Recommendation Report for Planning Permission for Works or Extension to a Dwelling

REF NO: FG/52/22/HH

LOCATION: 6 Beehive Lane
Ferring
BN12 5NL

PROPOSAL: Erection of two storey front extension with front canopy, single storey side and rear extension and extension of loft to habitable use including the installation of 1 x side dormer.

Drawing
Proposed Plans

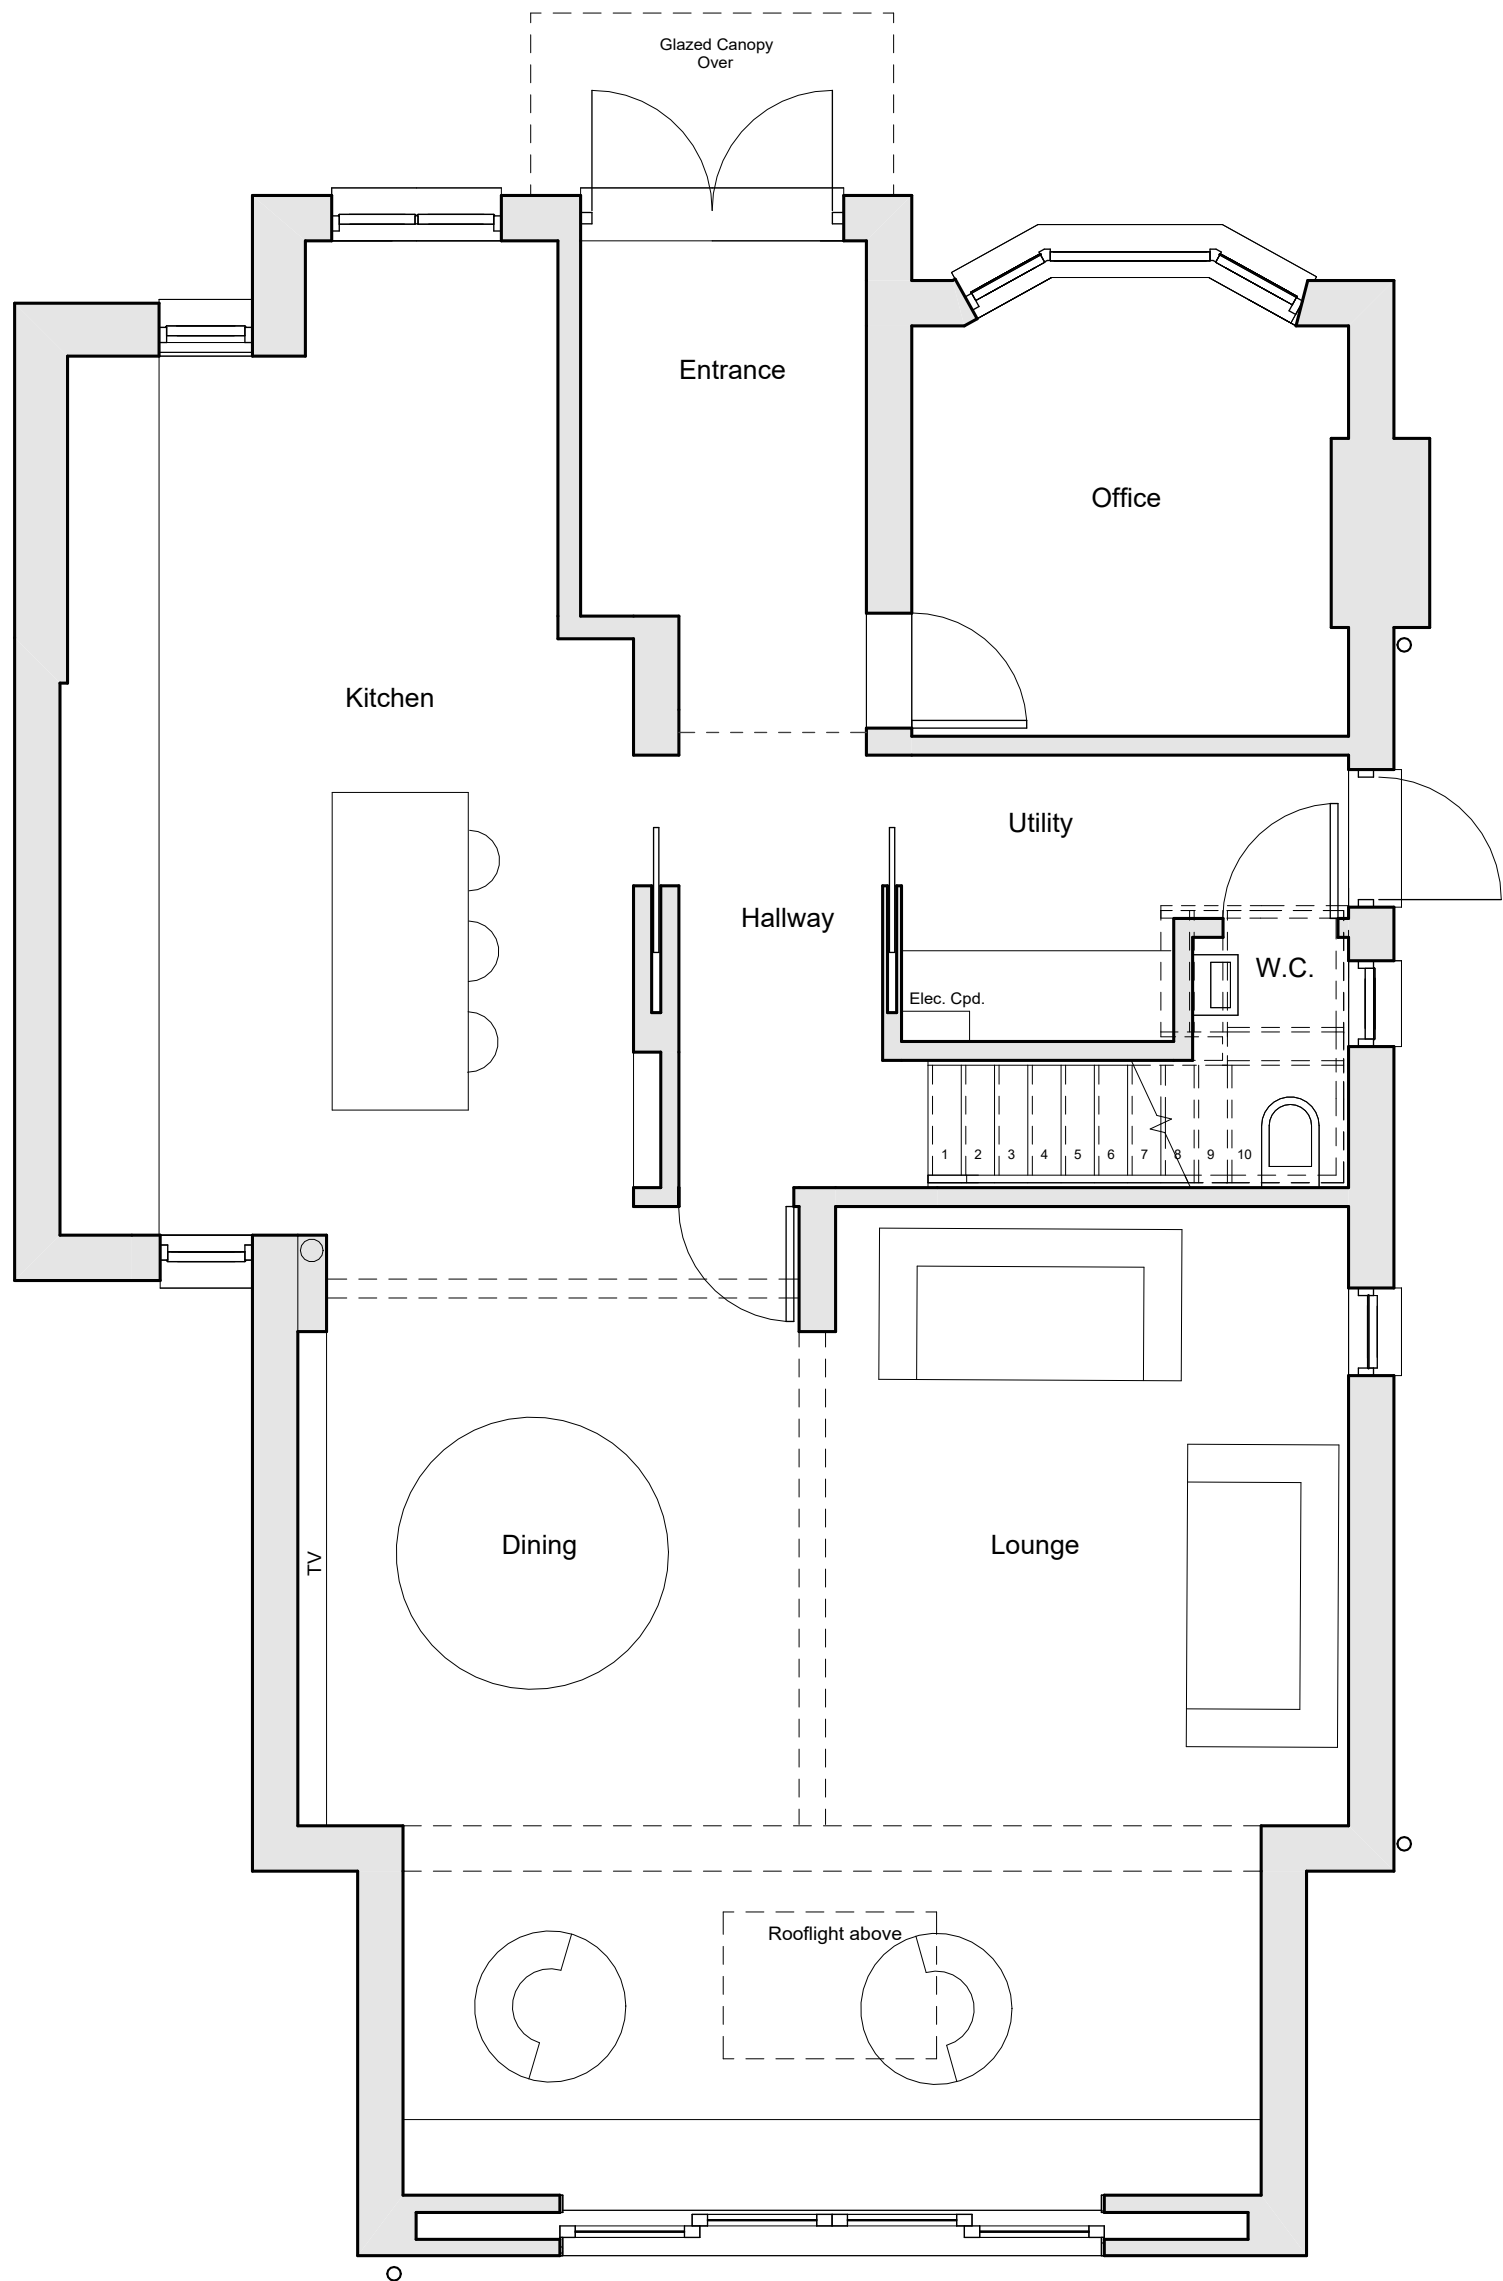
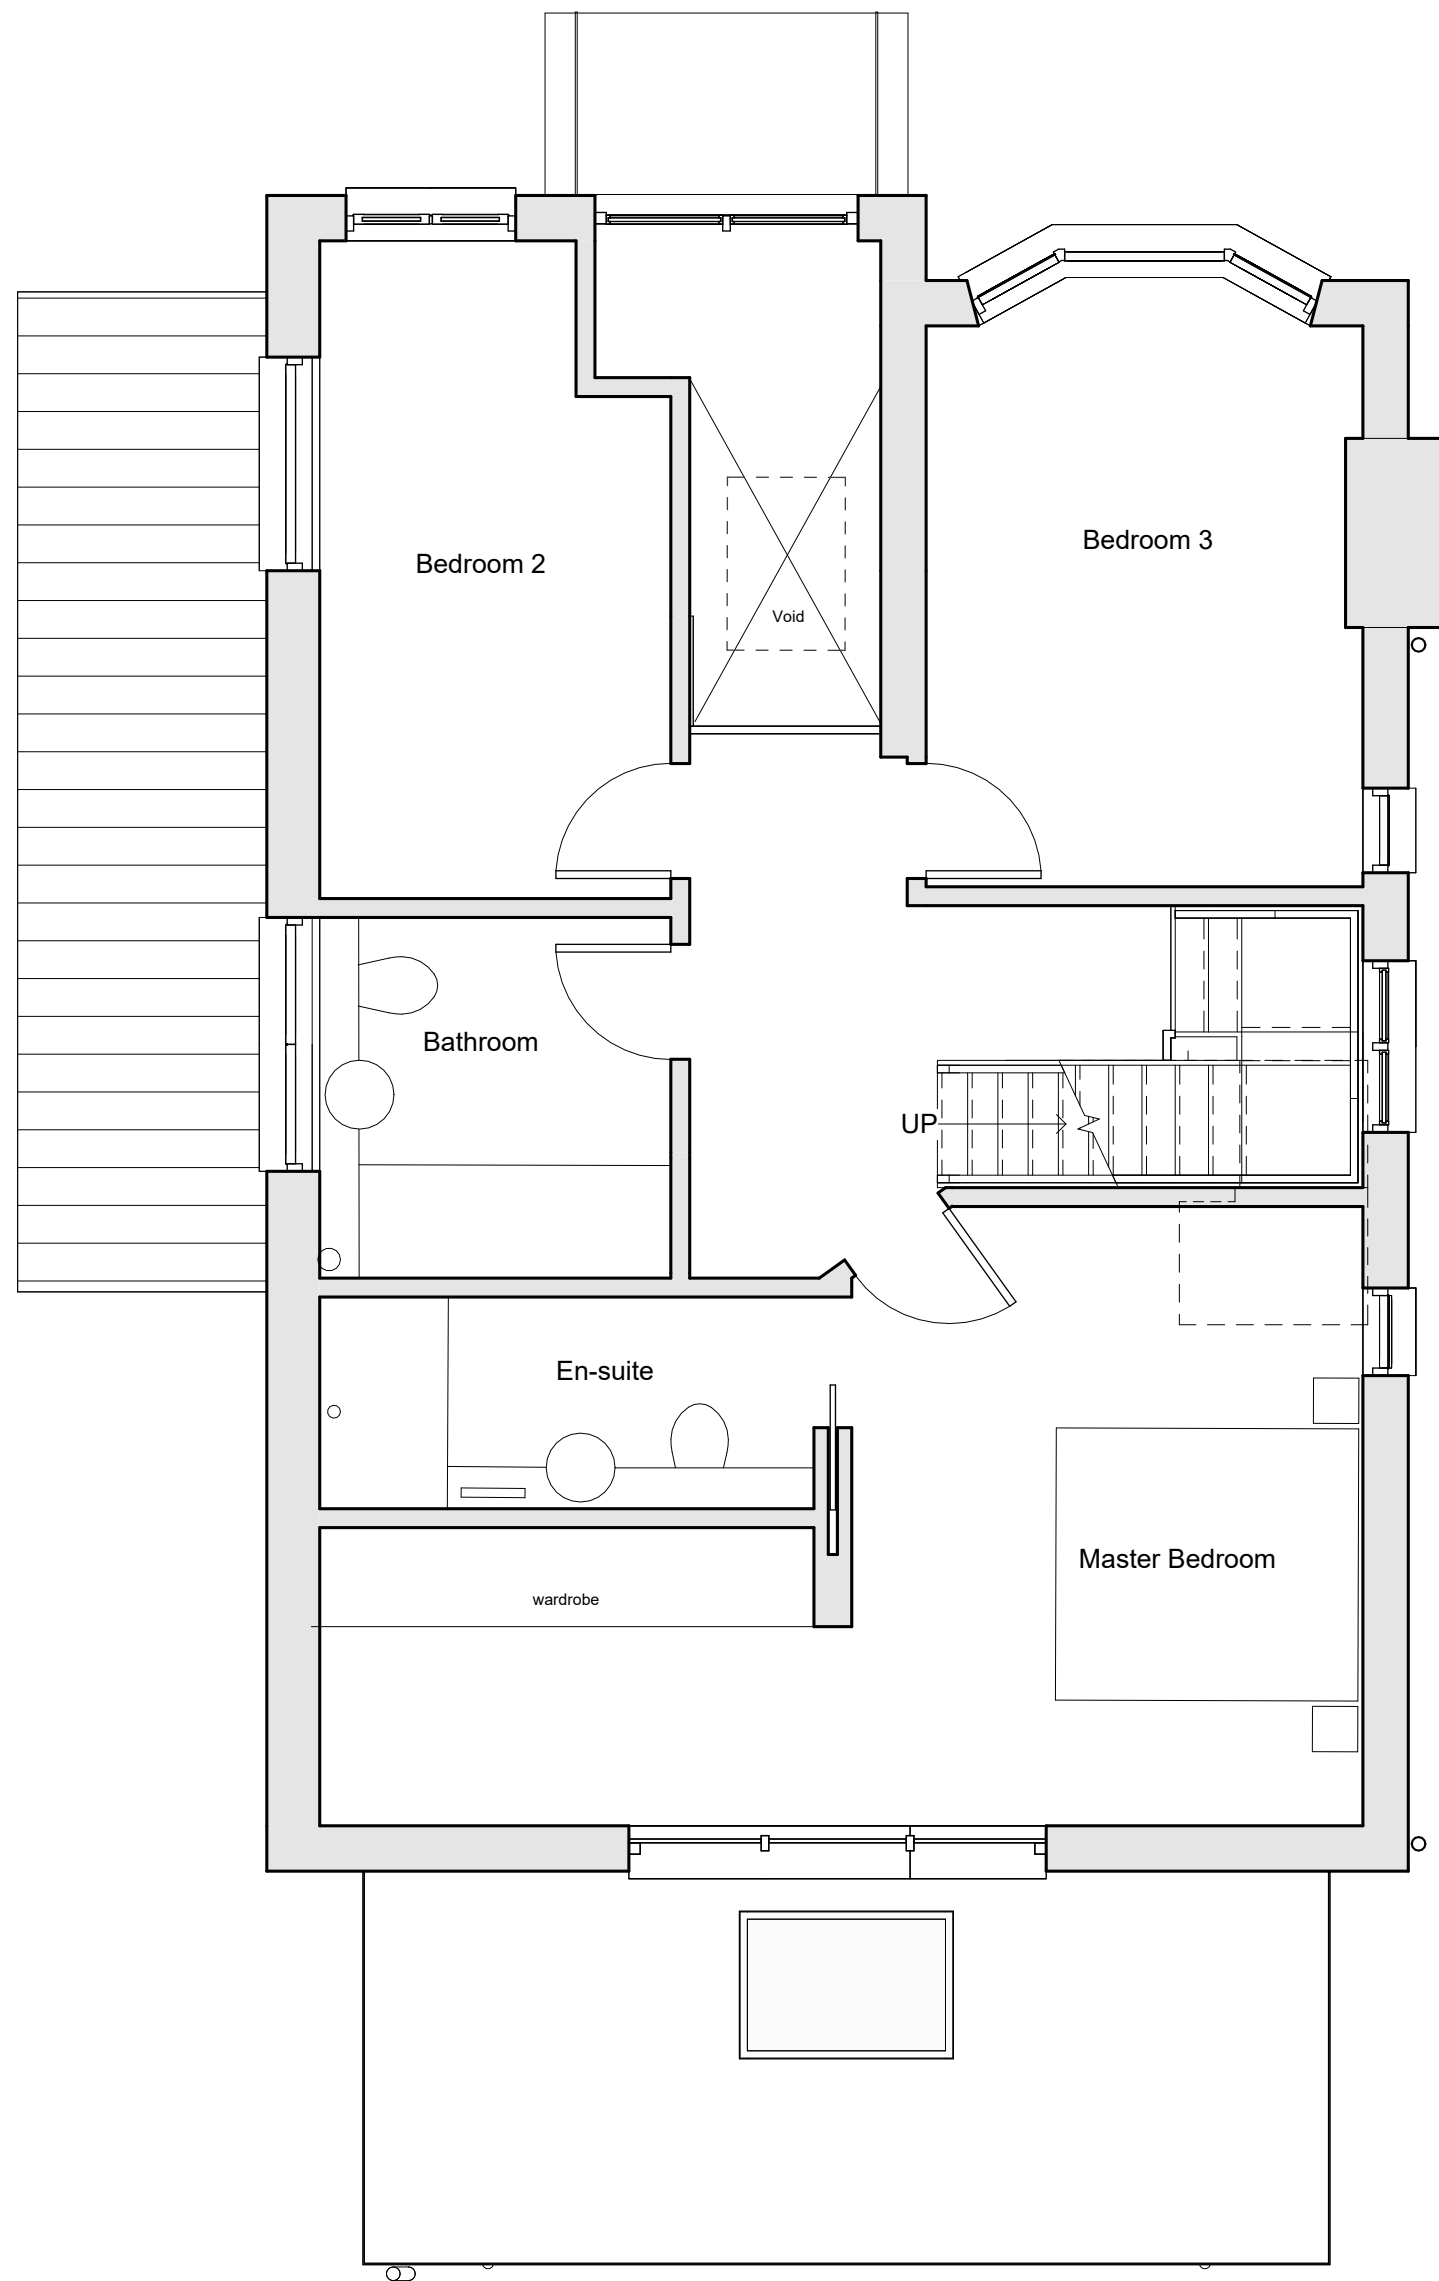
The proposed development will only encroach on the front (north) and side (western) boundaries, no development will extend past the existing line of the eastern or rear elevations. The single-storey side extension sits on the boundary with No 4A as the existing building does. To the west there is a 1.8m separation gap between the building and the shared boundary.

The single-storey side extension and two-storey front extension by reason of their location on site, orientation and scale are not considered to be overbearing or overshadow the neighbouring property to the west.

Comments have also been received regarding concerns for privacy through overlooking. No new views which are not already achievable will be created from any of the proposed fenestration located on the northern or western elevations. The roof lights to the western elevation appear to be above 1.7m from finished floor level, other windows face the public realm. The windows to the east are described within plans as obscure glazed, all other windows above ground floor levels are as existing. The glazed gable to the southern elevation has a direct back-to-back relationship with No 4 Chalet Close. The glazing at first floor level to the southern elevation will be lessening and will therefore improve the situation however, new glazing will be introduced at second floor level. This glazing replaces a much smaller rear gable which is set back by over 1.5m from the rear line of the elevation, by moving the glazing forward the 1.5m only 19m is retained between the two facing elevations, without control this would provide an unacceptable form of development. This window along with the other side windows/veluxes mentioned above will be conditioned to be non-opening and obscure glazed, to protect the privacy of all surrounding neighbours.

- Location and Block Plans 1002
 - Proposed Plans 2002 02
 - Proposed Elevations 2003 02
Reason: For the avoidance of doubt and in the interests of amenity and the environment in accordance with policy D DM1 of the Arun Local Plan.
- 3 The second floor rooflights/windows hereby approved to the western, eastern and southern elevations shall be non-opening and fully obscured windows below 1.7m from finished floor

The first floor window to the western elevation serving Bedroom 2 shall be a non-opening and fully obscured window below 1.7m from finished floor level prior to the first use of the rooms. The window shall be retained as obscure glazed/non-openable in perpetuity.
